Item No. **Report of the Head of Planning, Building Control, Sport & Green Spaces**

Address LAND ADJACENT TO 171 NORTH HYDE ROAD HAYES

Development: Erection of two storey building comprising ground floor shop, two bedroom flat at first floor level and associated parking (Part Retrospective)

LBH Ref Nos: **11980/APP/2015/1160**

DRAWING NUMBER:
171/UB34NS/001

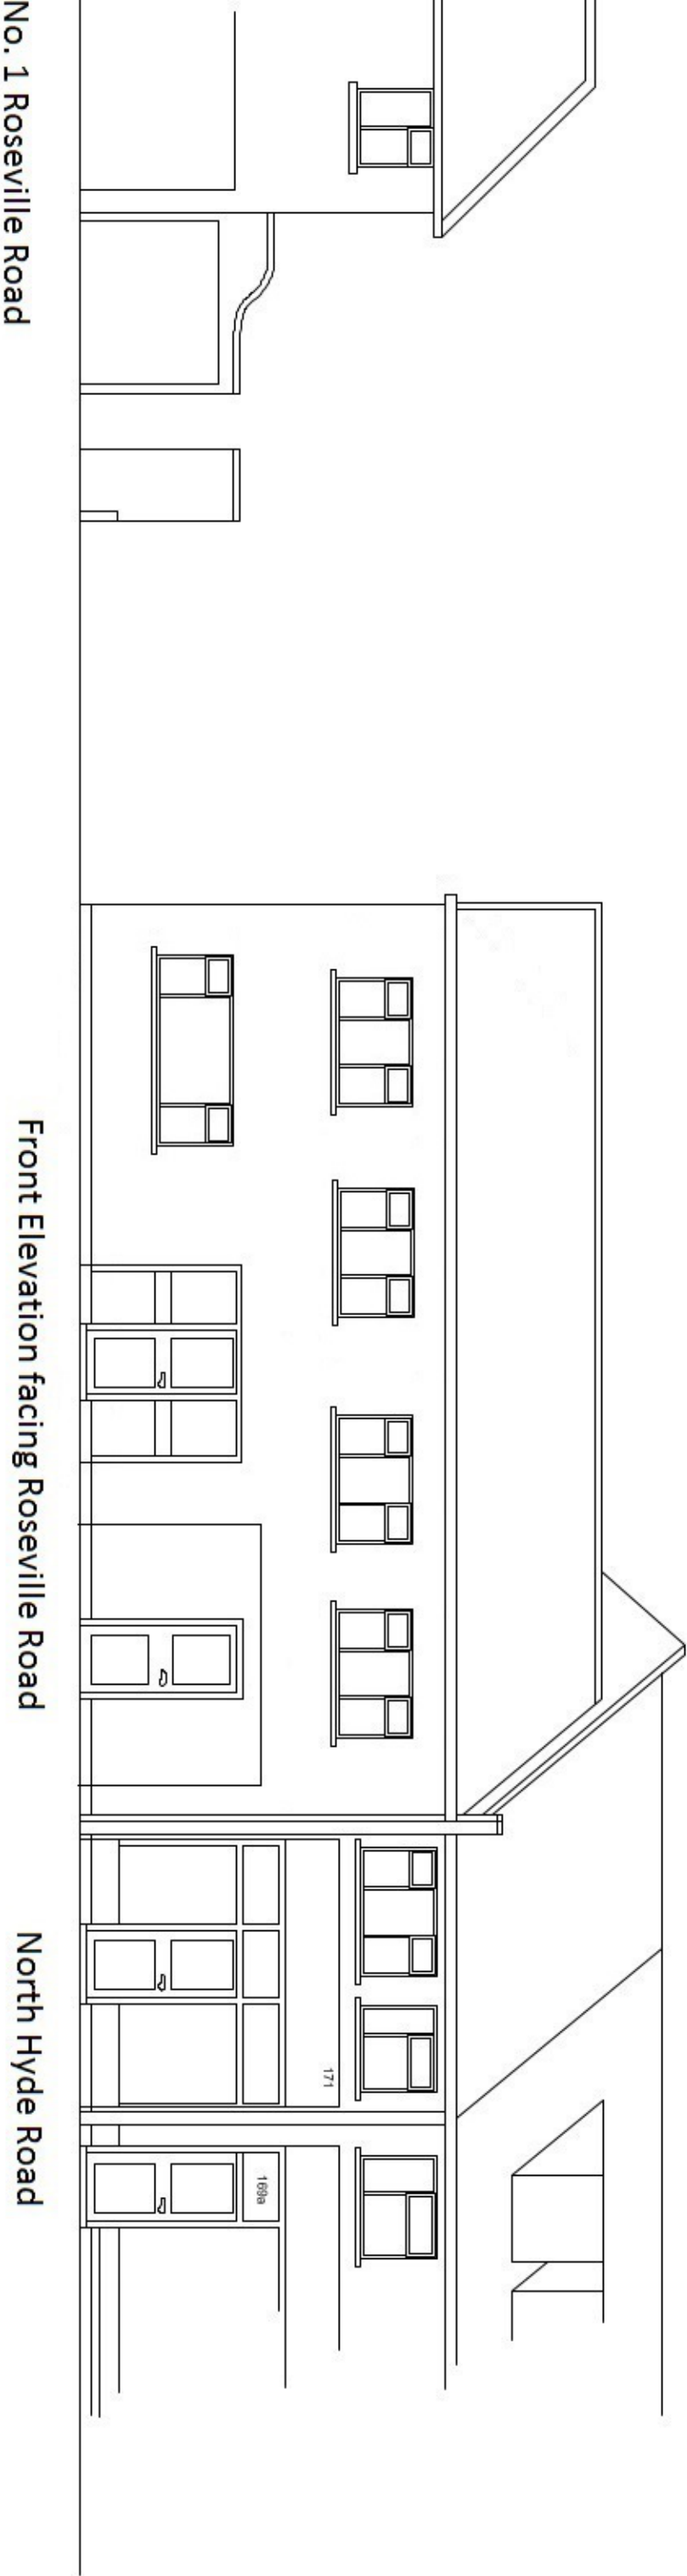
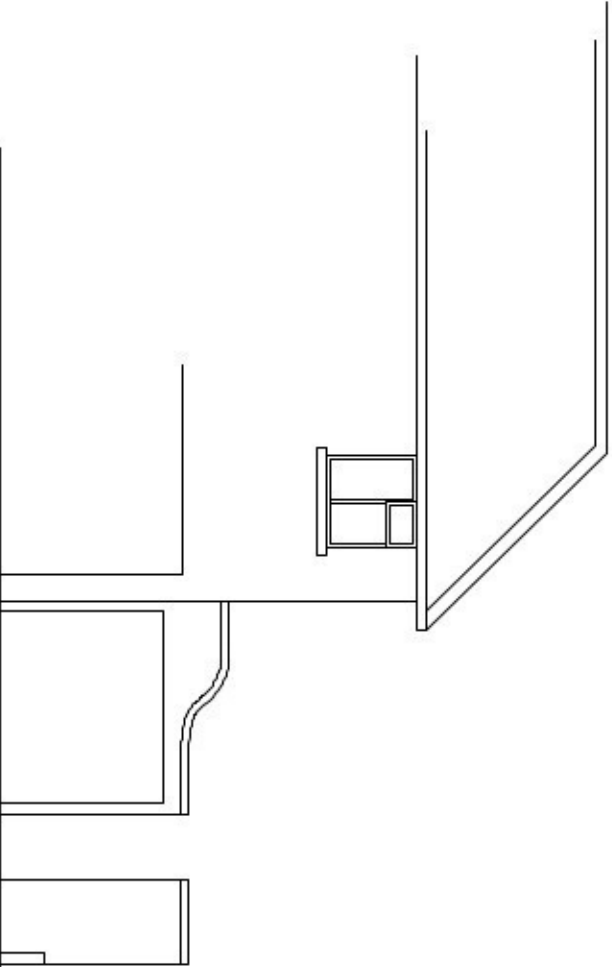
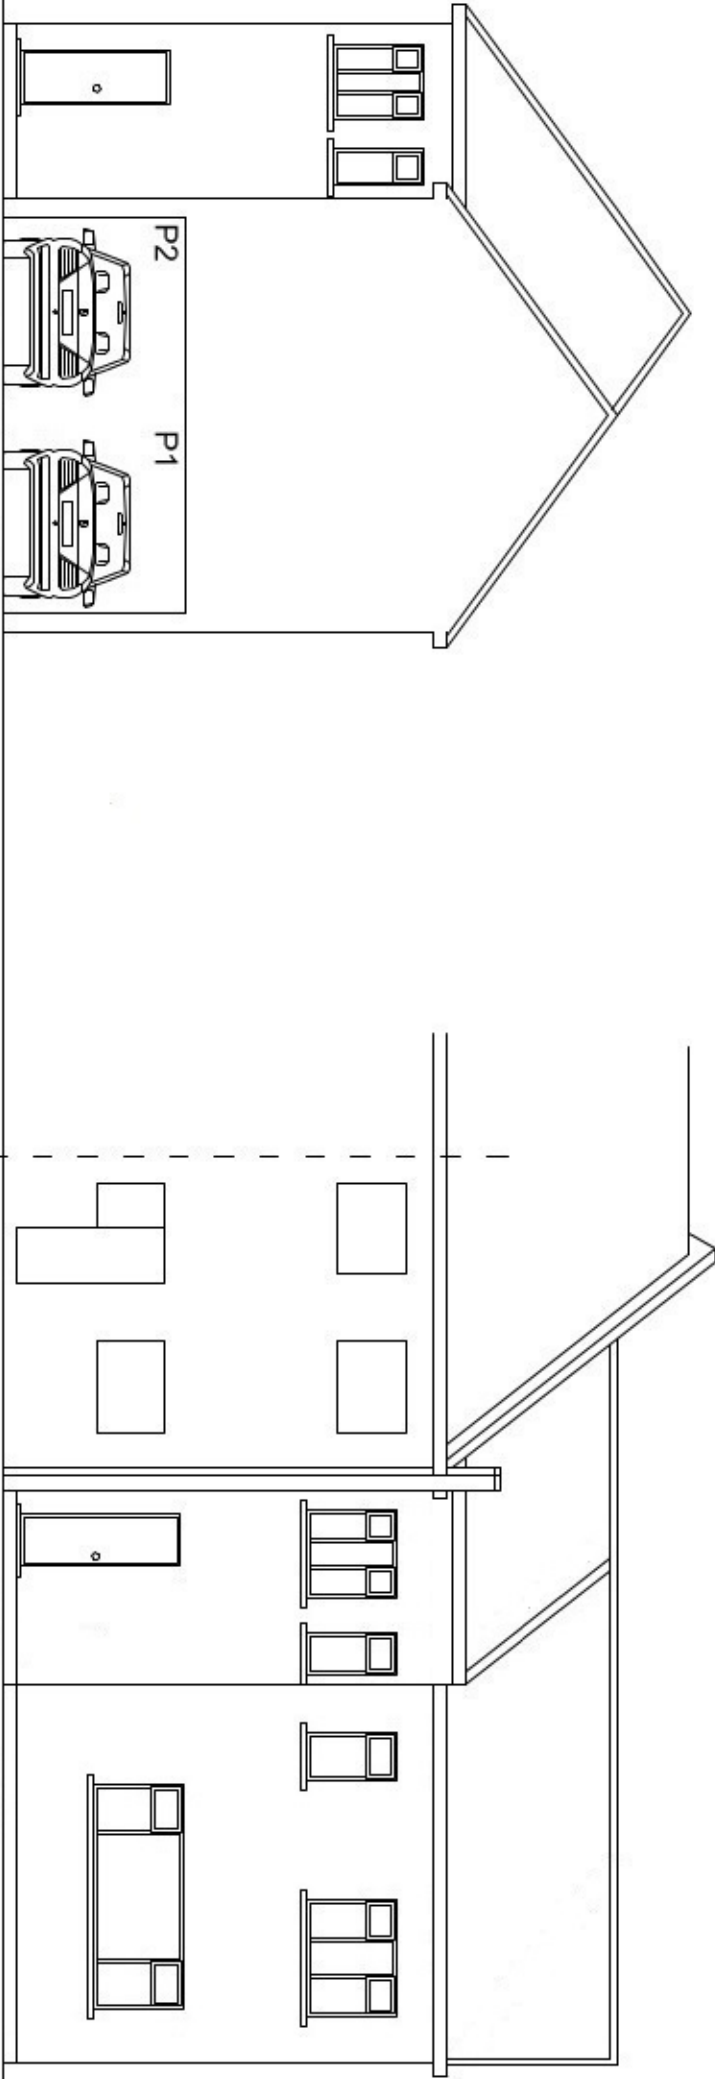
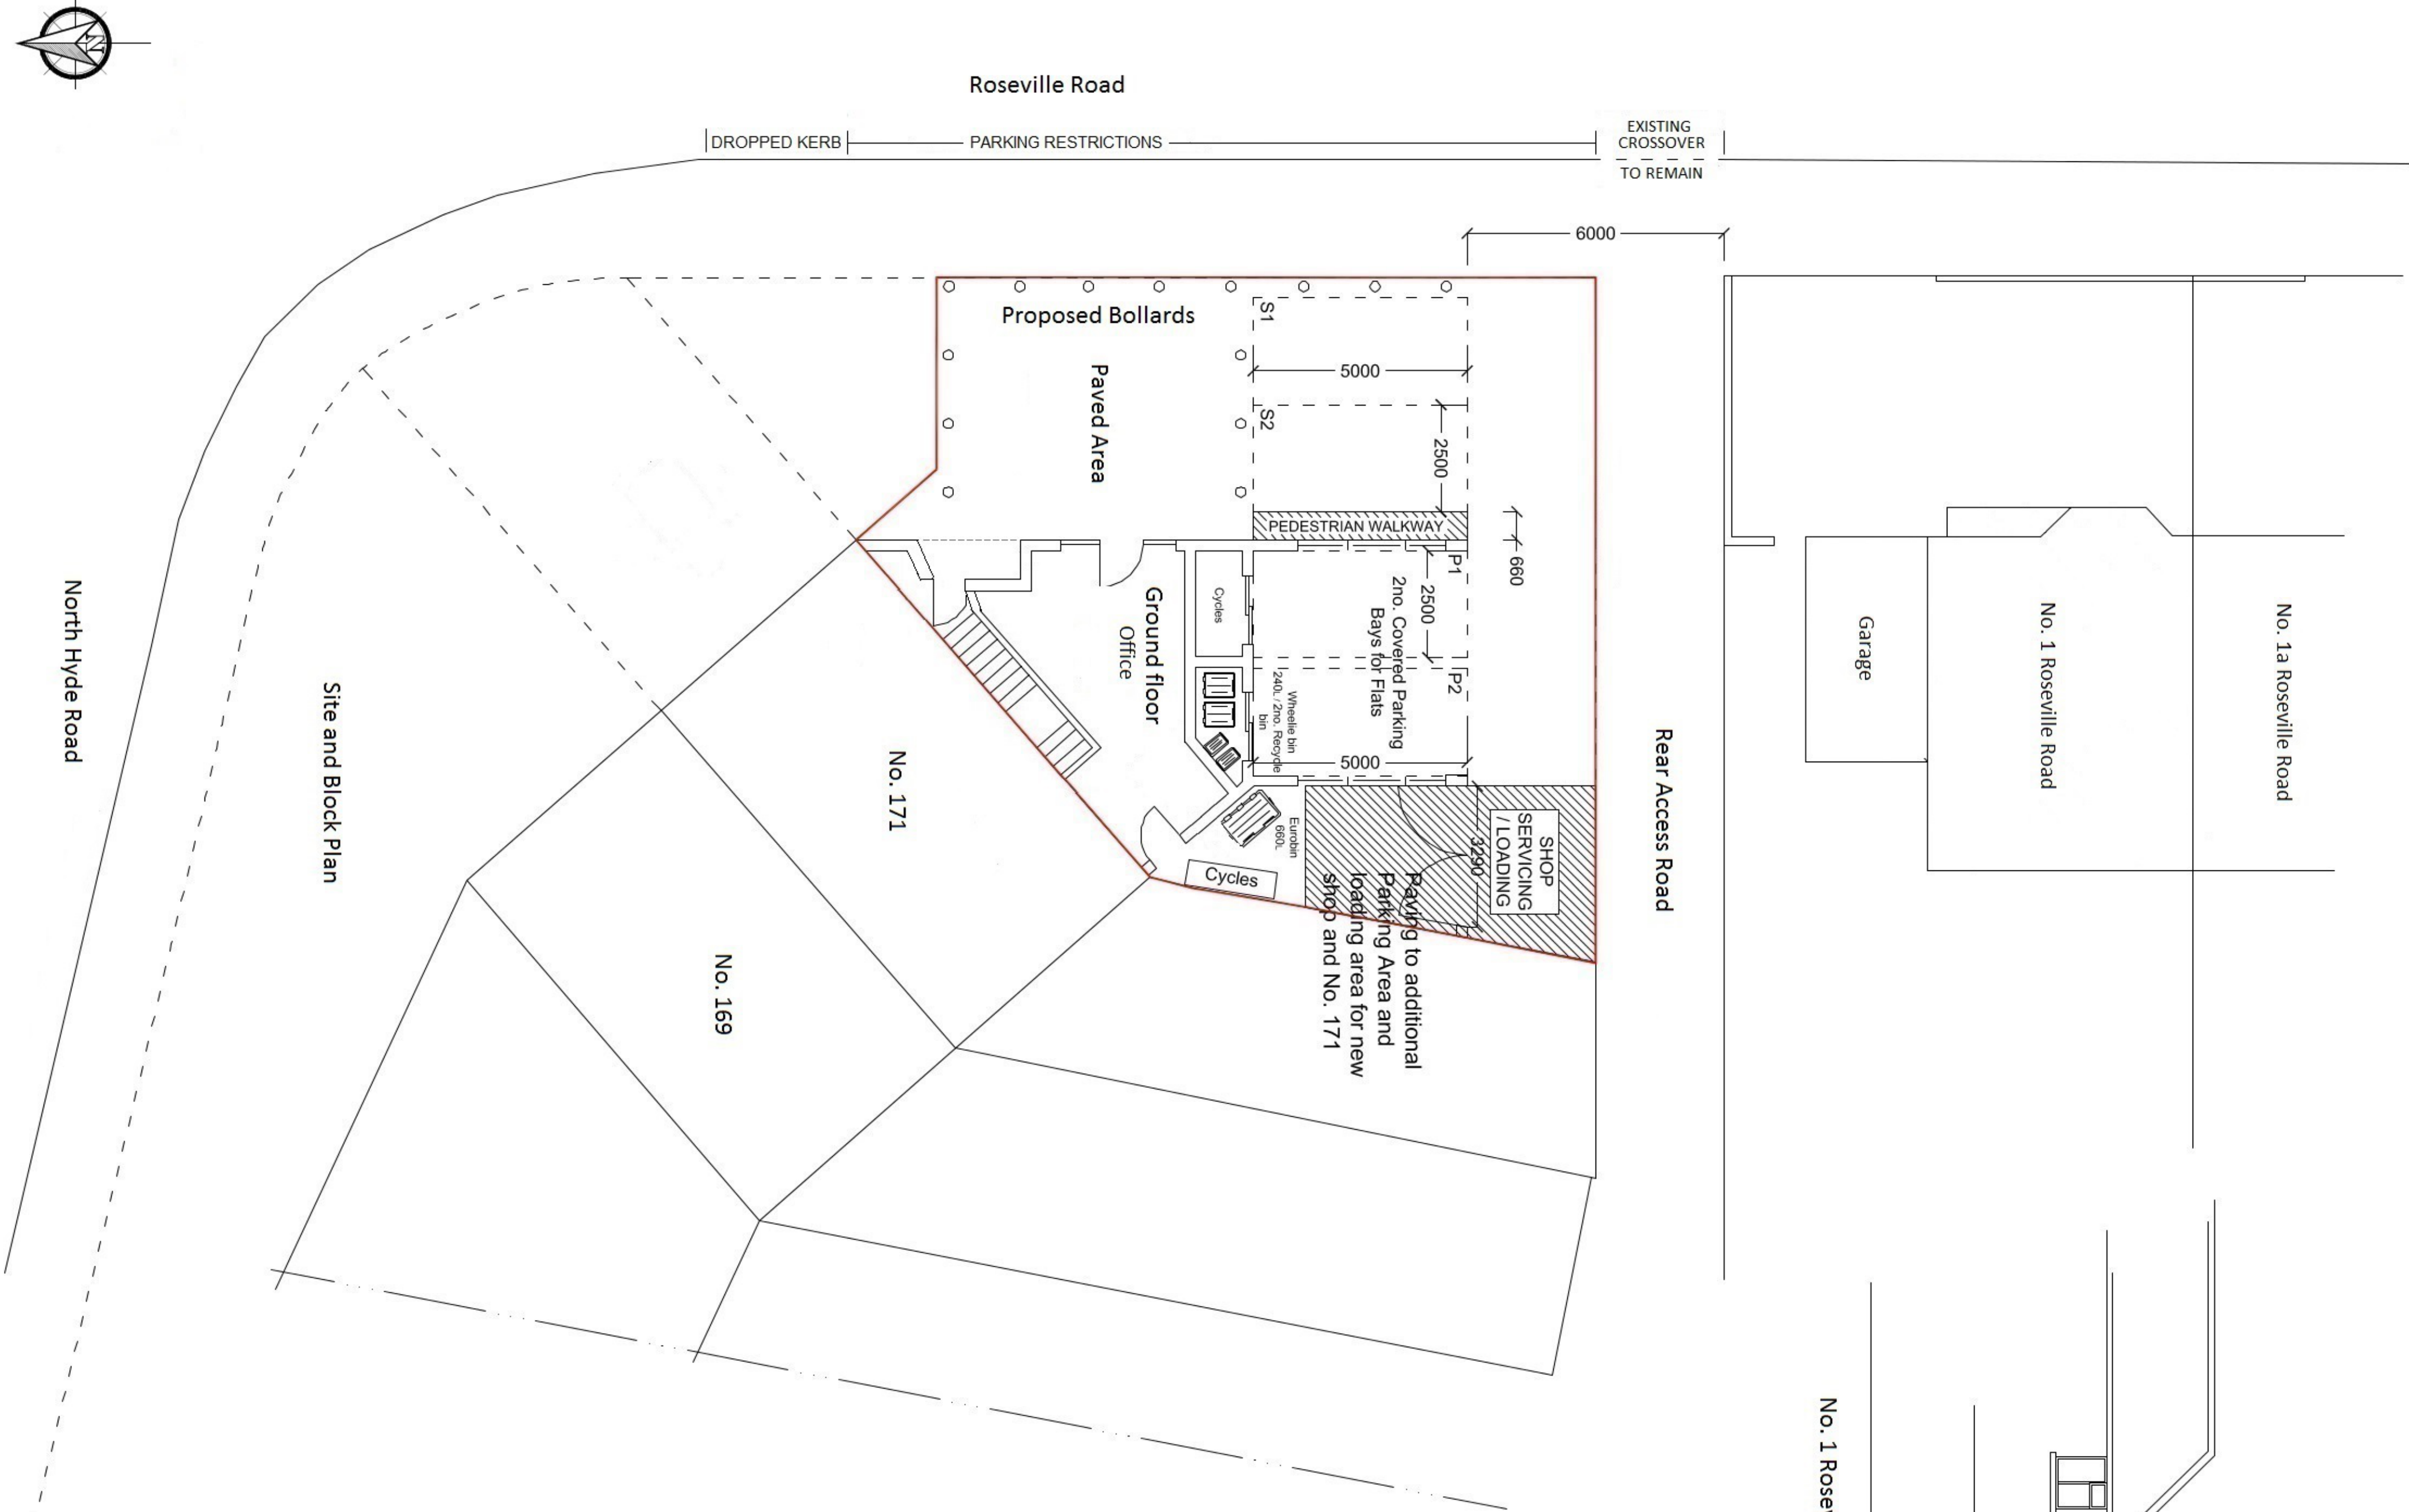
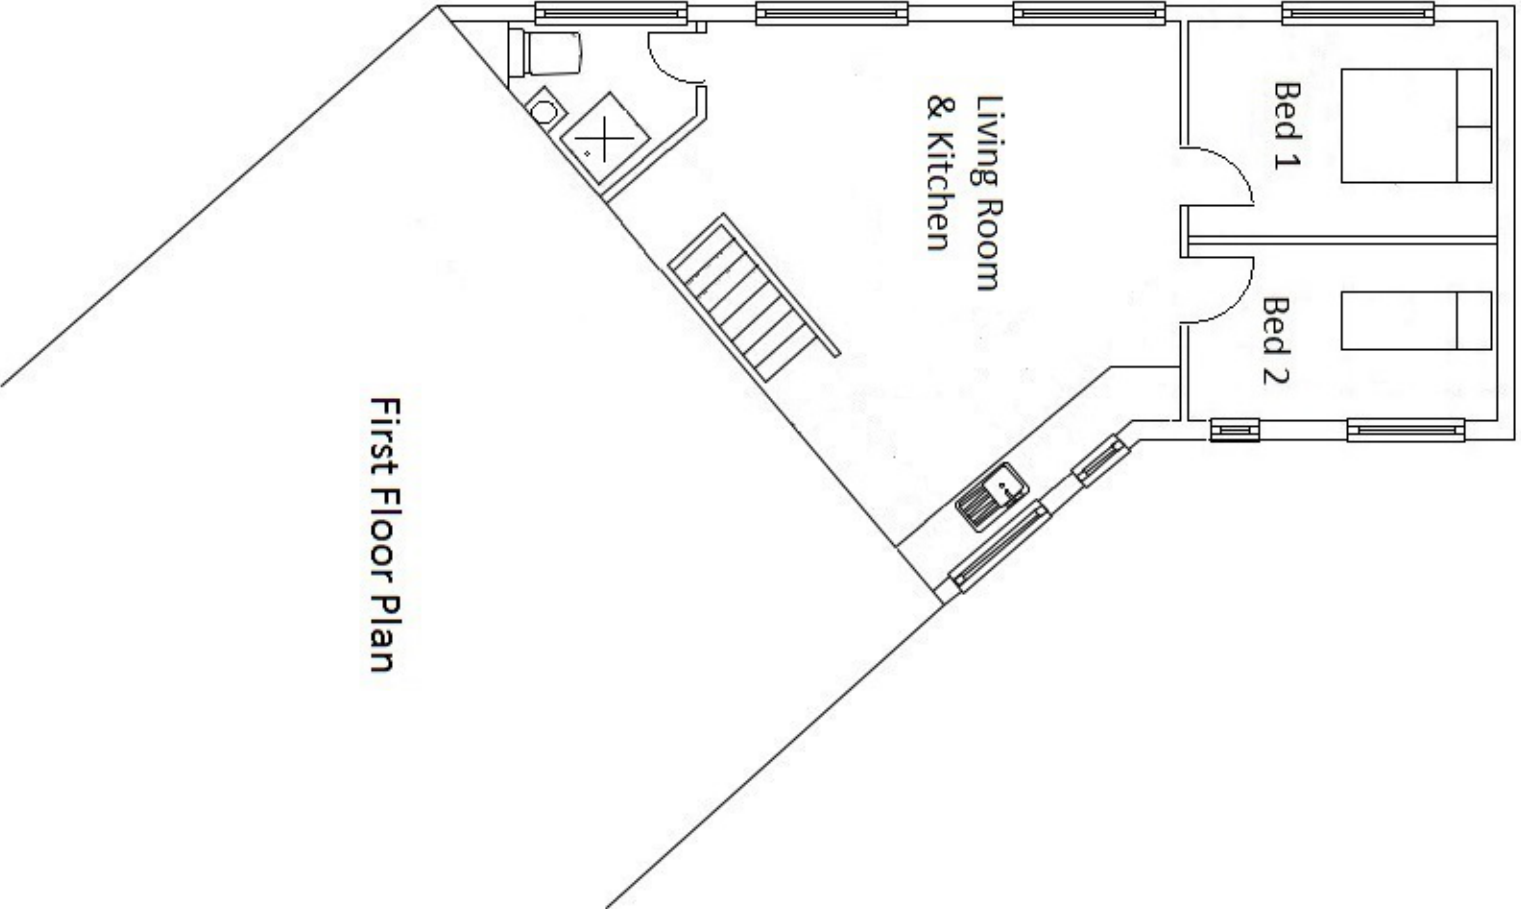
The proposal is to authorise the existing development comprising the erection of a two-storey building with end gable roof with shop/office on ground floor, two bedroom flat on the first floor and an open carport to the rear as shown on drawing no: 11/UB34NS/001 Rev. B received 22nd May 2015. The rear dormer, first floor side gable window and walls and gates surrounding the car port are to be removed as part of this re-submitted scheme. The internal layout of both the shop/office and the upstairs flat have also been revised and are acceptable.

The previous application provided 2 open ended car port spaces for 2 covered spaces for the first floor flat. On the sides of the car port was shown an open area with railings which provided visibility as well as security. this arrangement was approved. However, the applicant inserted windows into the areas where railings had been agreed and extended the carport with a 2m high wall on both sides to the service road installing timber gates effectively closing in the carport area. The applicant has stated that this is for security purposes as builders materials and equipment were constantly being stolen and also for the increased security of the future tenants.

However, the walls and the gates are considered to reduce visibility significantly when existing the carport and the Highways officer recommended a refusal based on highways grounds. In previous correspondence stating:

Pedestrian visibility splays of 2.0m x 2.0m are required to each side of the open and covered parking bays where the timber gates meet the rear access road. There should be no obstruction within the visibility splays over a height of 0.6m. The open gates and the supporting walls to the covered car parking bays would present unacceptable obstruction to pedestrian visibility splays.

It was then proposed to reduce the height of the walls to 0.6m with railings above but with the timber gates opening inwards these would still block visibility and further amendments were sought to remove the wall and the rear gates in their entirety. This is shown on the plans received 22nd May 2015 of which the Highways Comments of the 26th May 2015 relate.

The removal of the rear dormer

The removal of the rear first floor gable end window

The removal of the eastern wall and the rear timber gates of the car port

The removal of the door leading from the ground floor A2/B1 office to the car port.

The blocking up of the entrance door between the internal staircase to the first floor flat and the ground floor A2/B1 office unit.
